Final Plat 1st Review Responses.pdf Markup Summary

FINAL PLAT
 BENT GRASS EAST COMMERCIAL FILING NO. 4
 JOB NO. 70-110

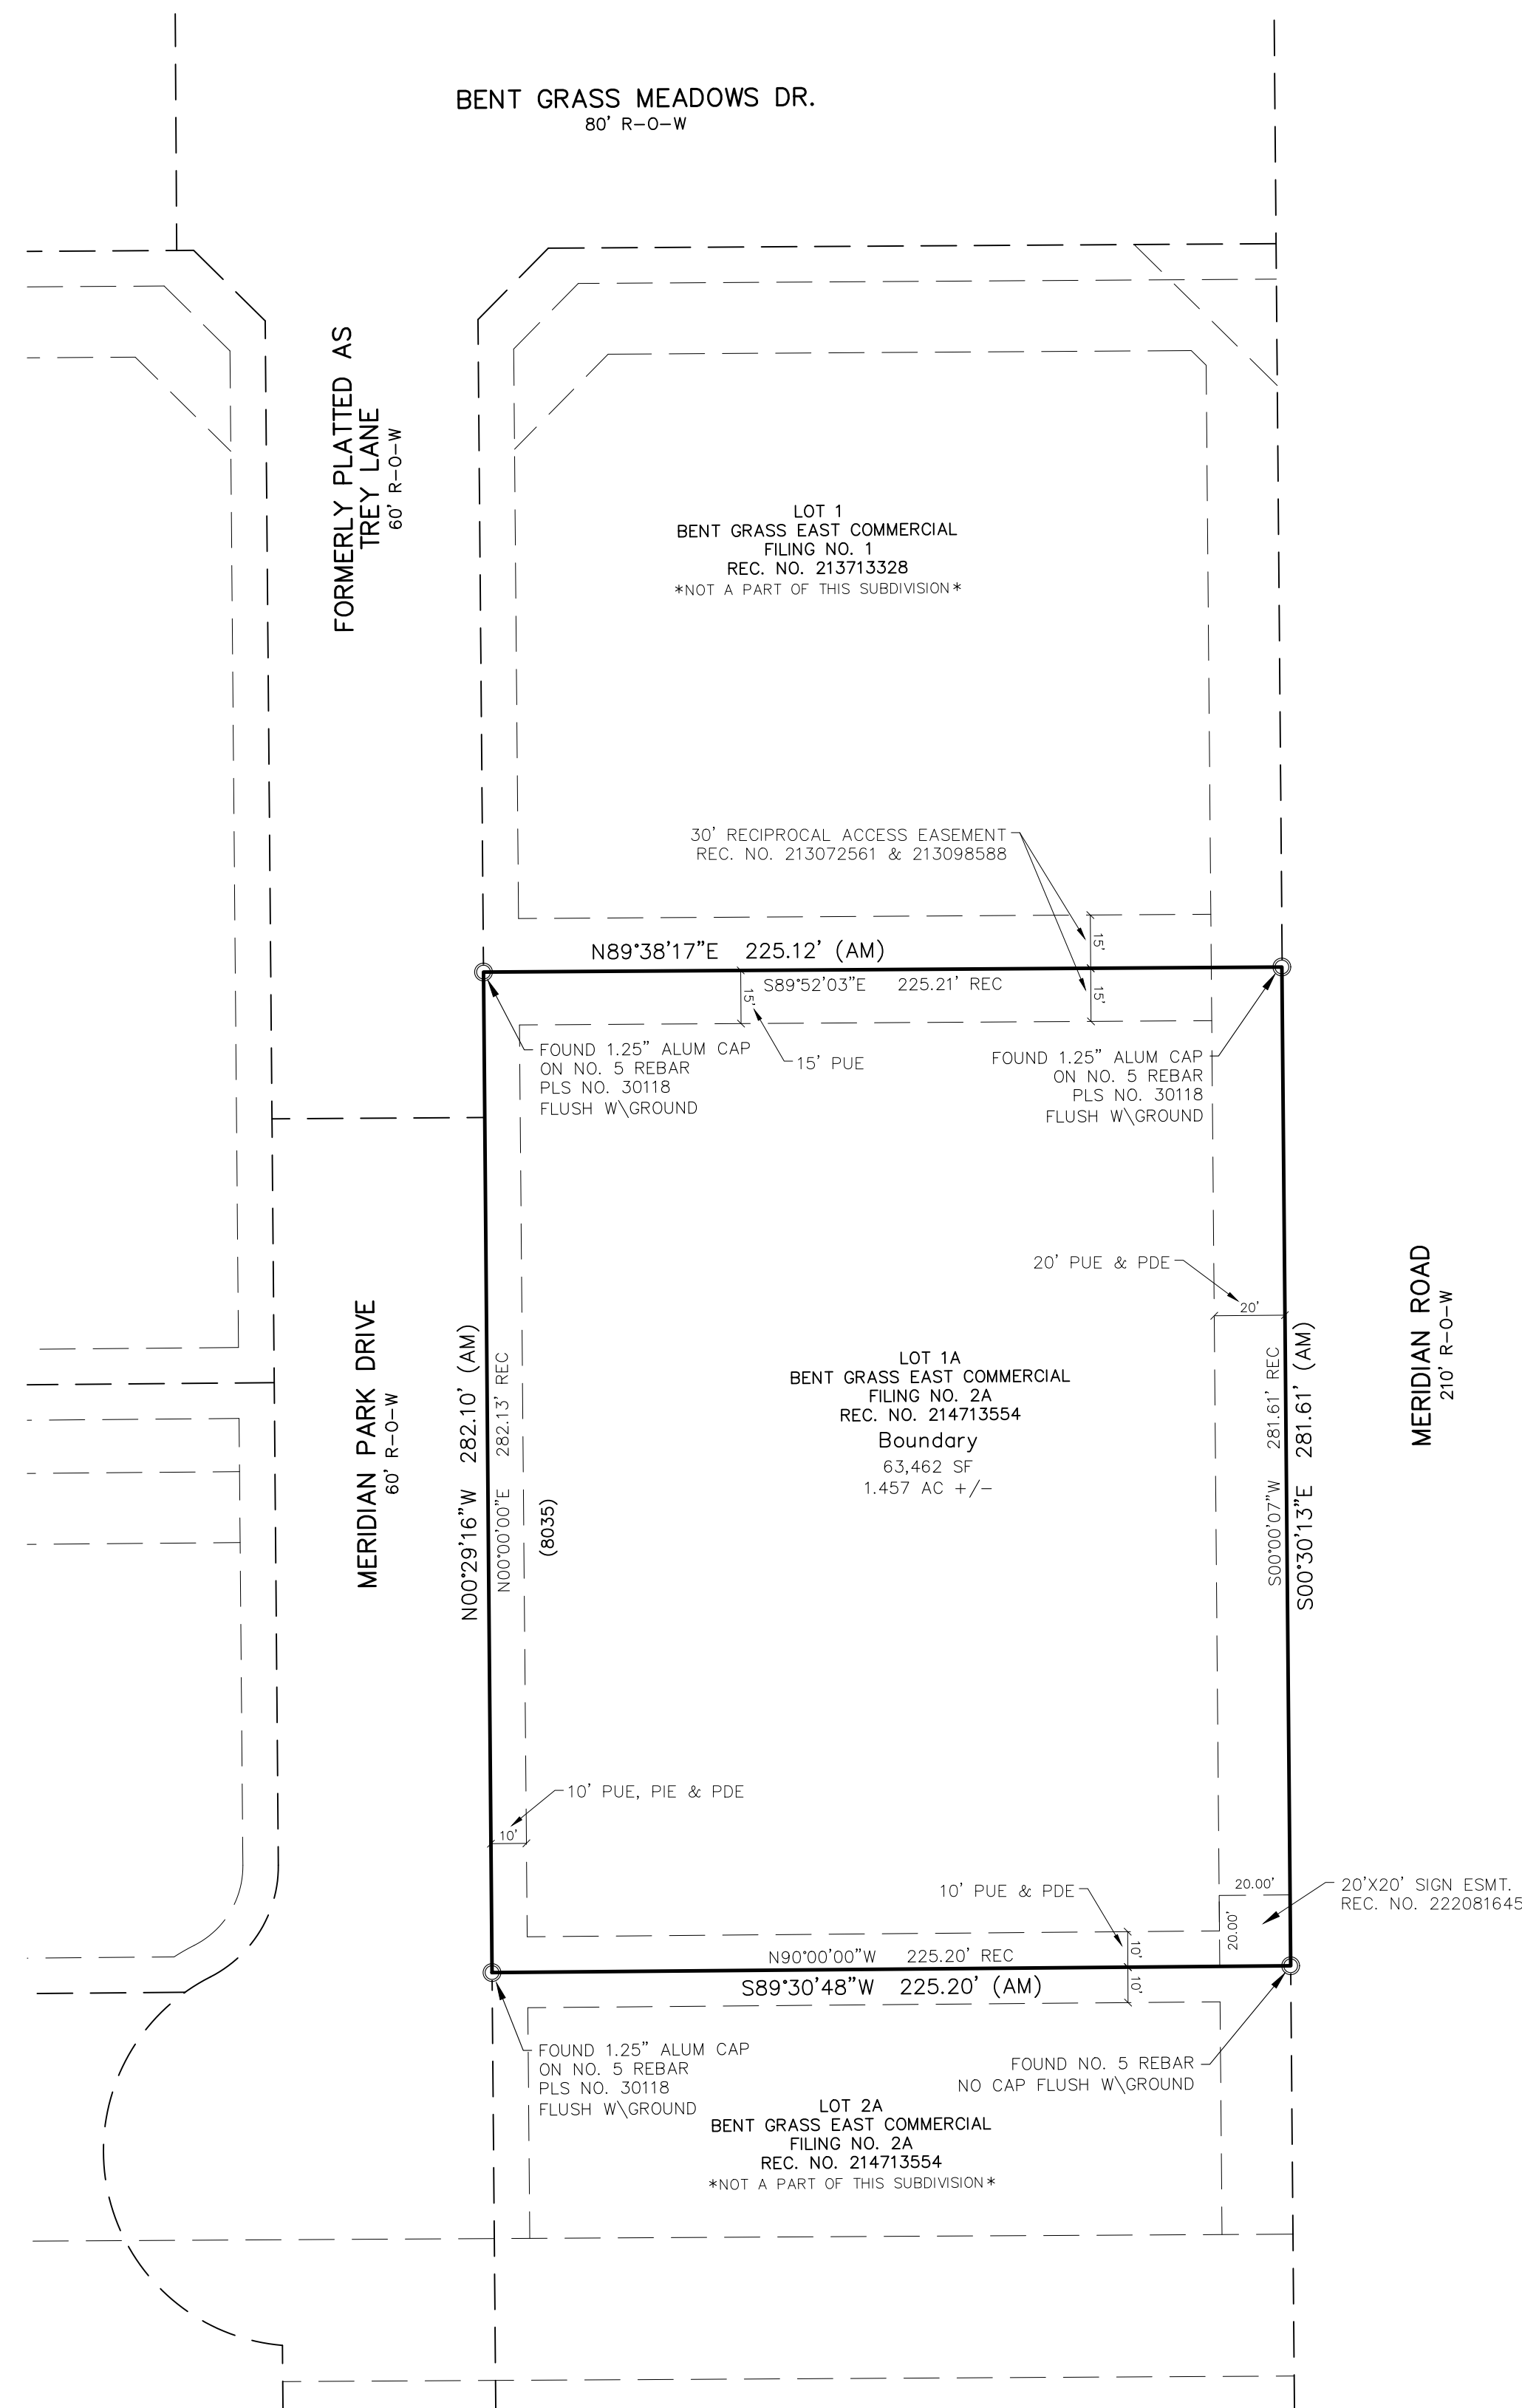
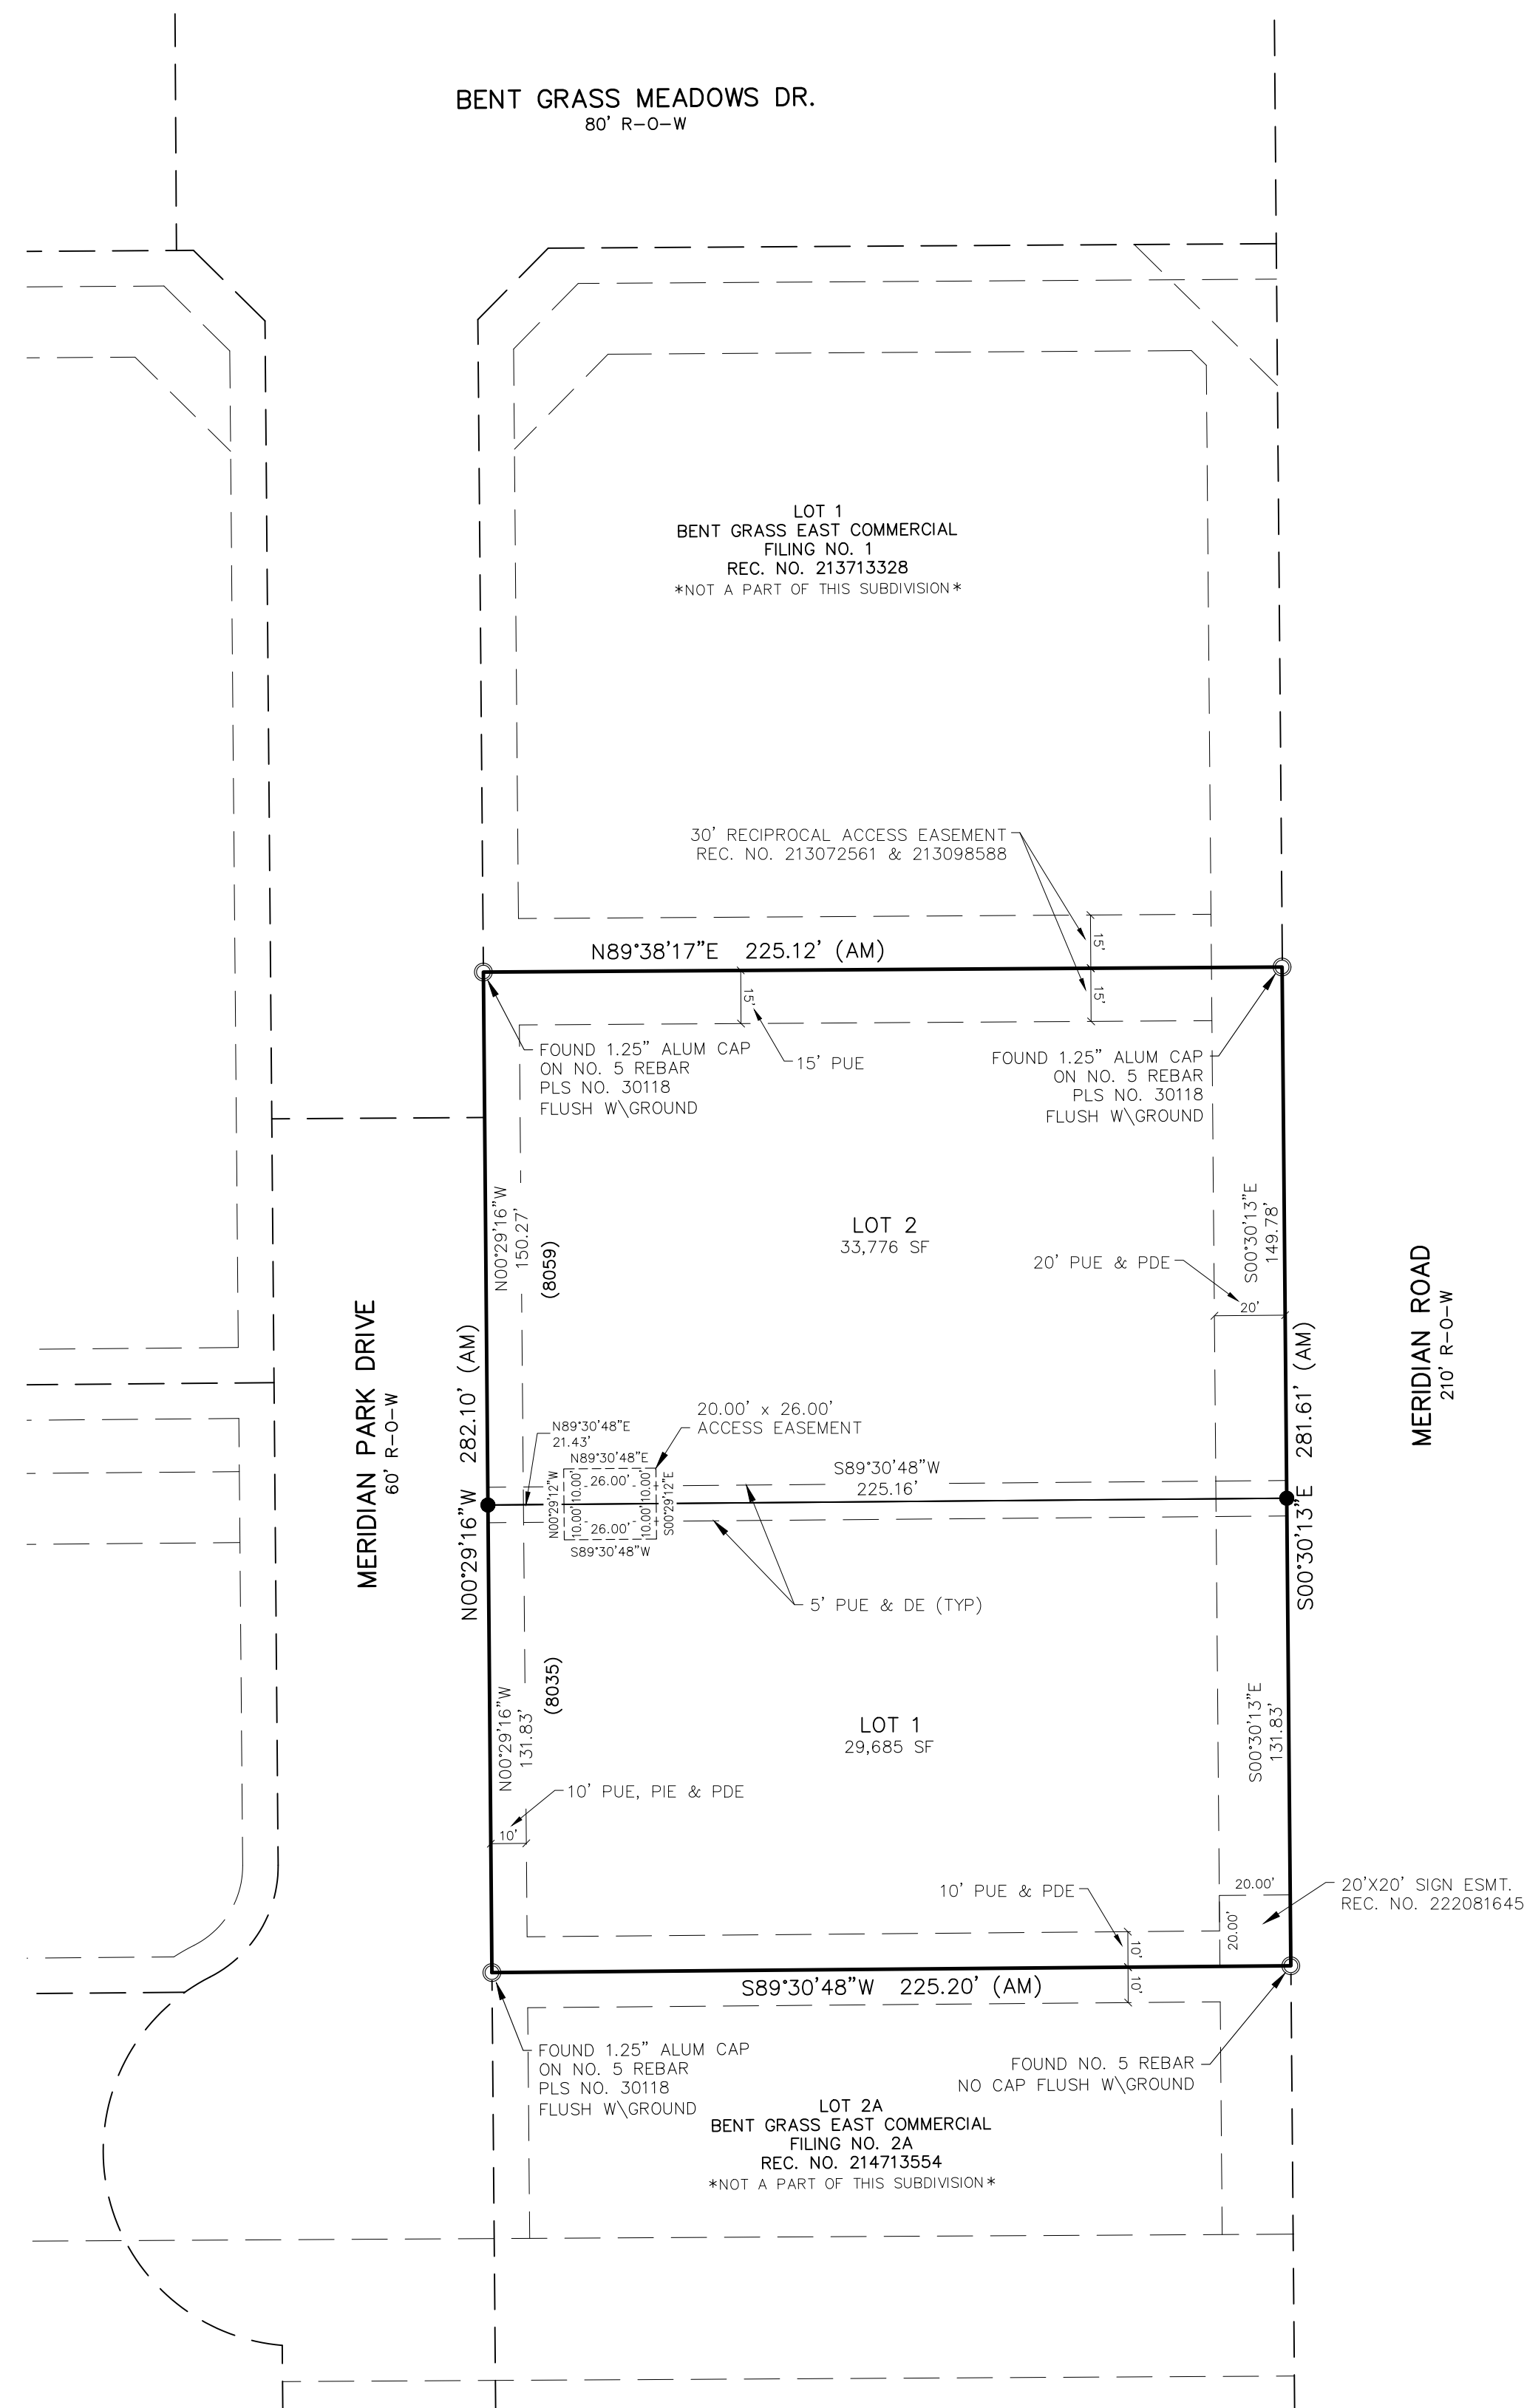
show and label the joint access easement
Ensure access spacing meets standards

Any lot or parcel not a part of the project shall have "not a part of this subdivision" with it

add current plat #

Cross access easement location not defined or shown; addressed by new plat note 18.

"Not A Part Of This Subdivision" added to parcels outside of replat area as requested.

Reception number of current plat added.
